Stage 1 Road Safety Audit Report

Mayo County Council

May 2025

N59 CARROWREVAGH BRIDGE REHABILITATION WORKS

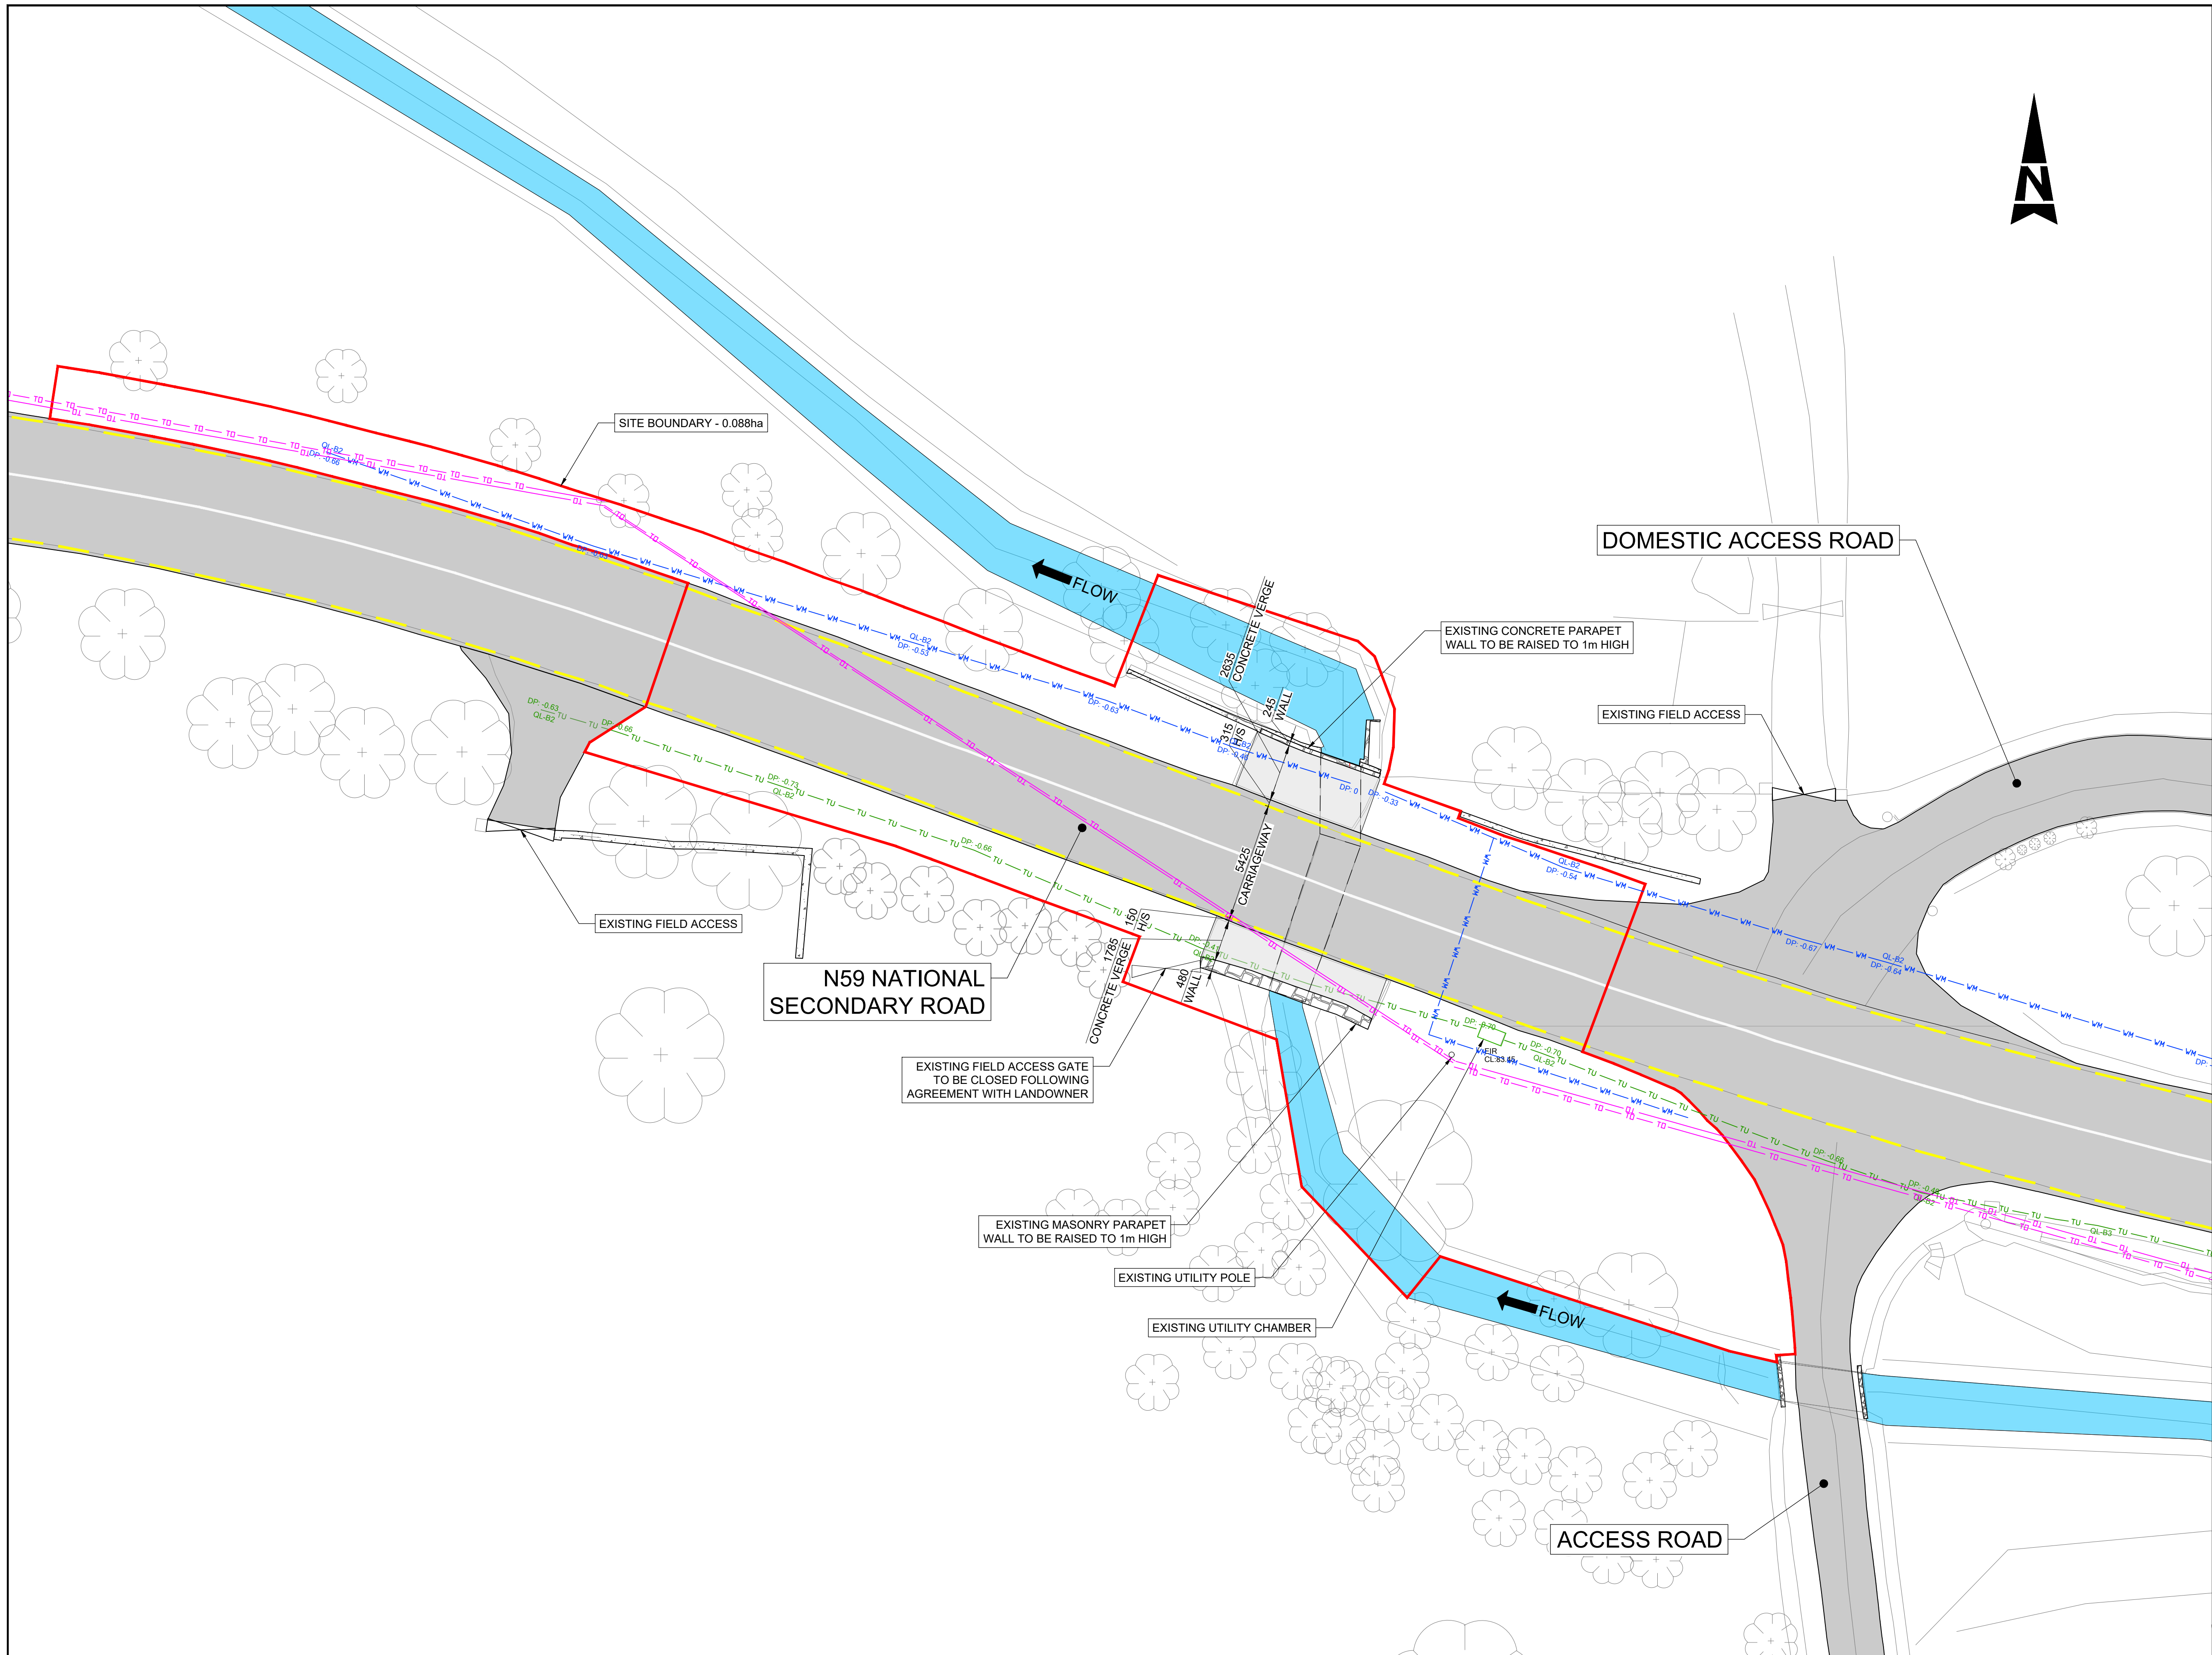
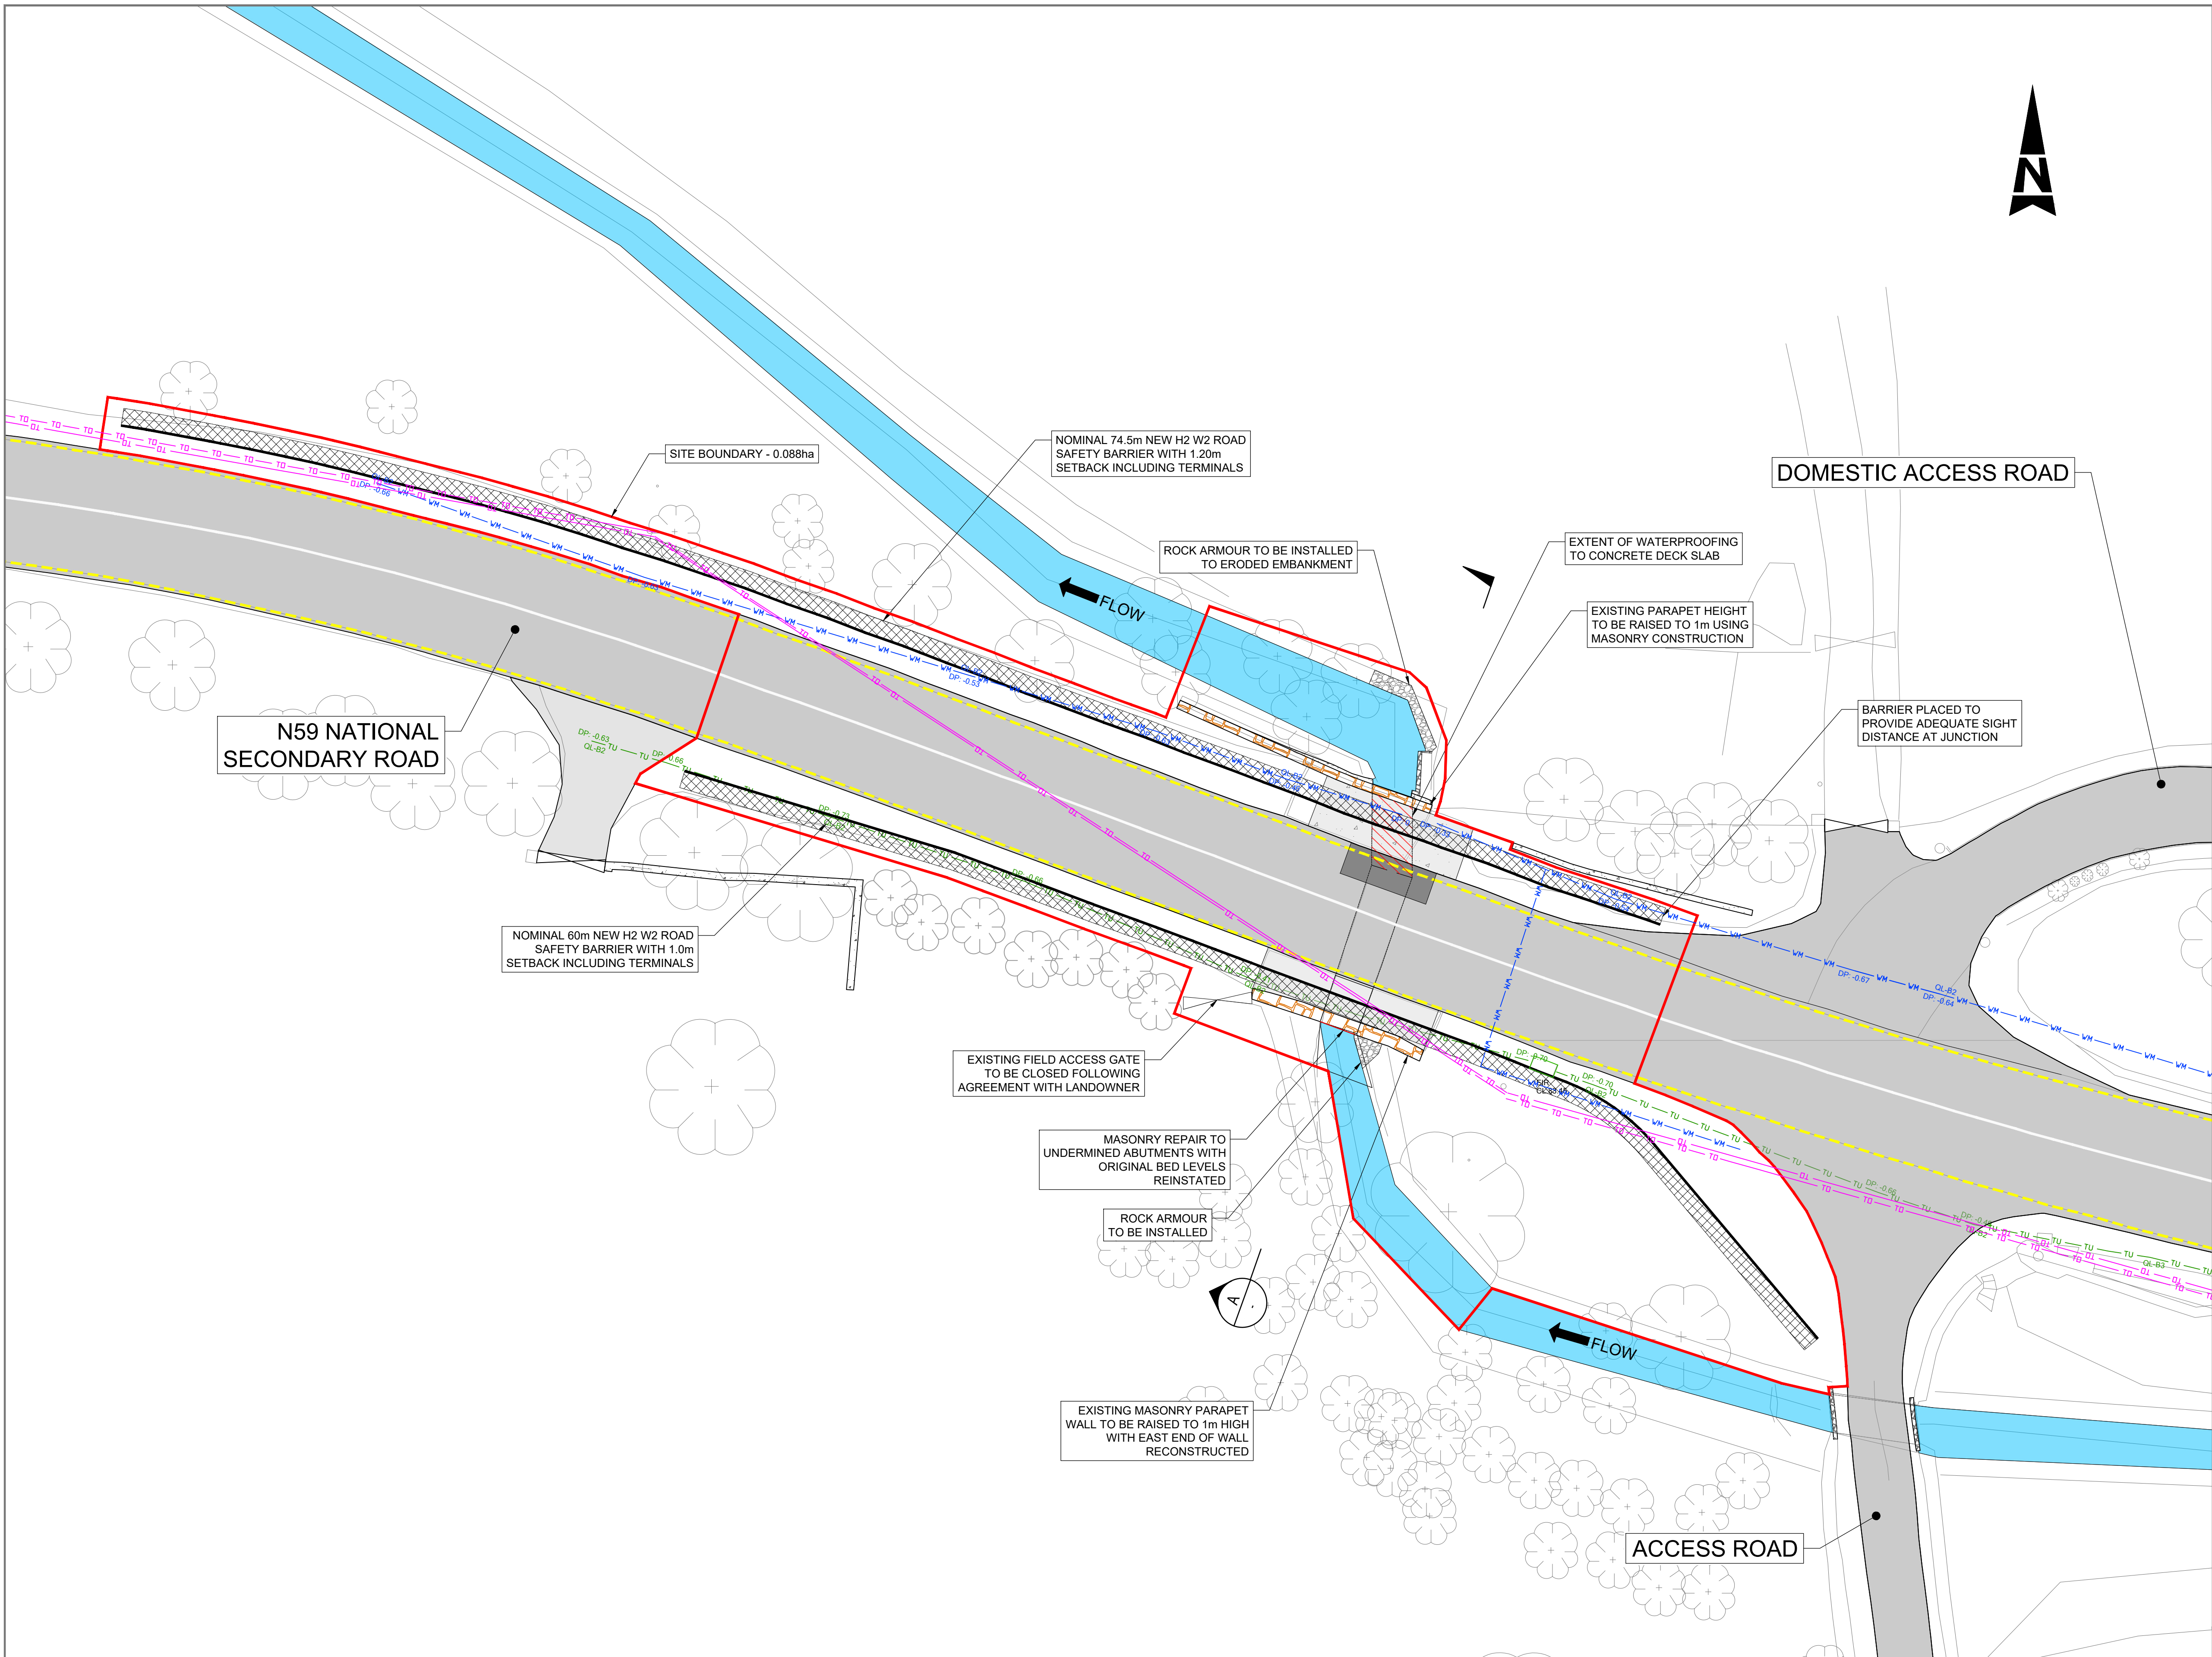
The proposed safety barrier may partially obscure drivers' sight lines at the field and house accesses on both sides of Carrowrevagh Bridge (see figure below), potentially increasing collision risks on the N59.

Assess sight lines at the accesses and adjust the safety barrier (if required) to optimize visibility.

2.1	Yes	Yes	Sightlines have been assessed with the end of the safety barrier on the southwest departure to be flared to avoid impact on sightlines from the field access. The sightlines from the domestic entrance northeast of the bridge location are not affected by the proposed barrier due to the relative ground levels at the location.	Noted.
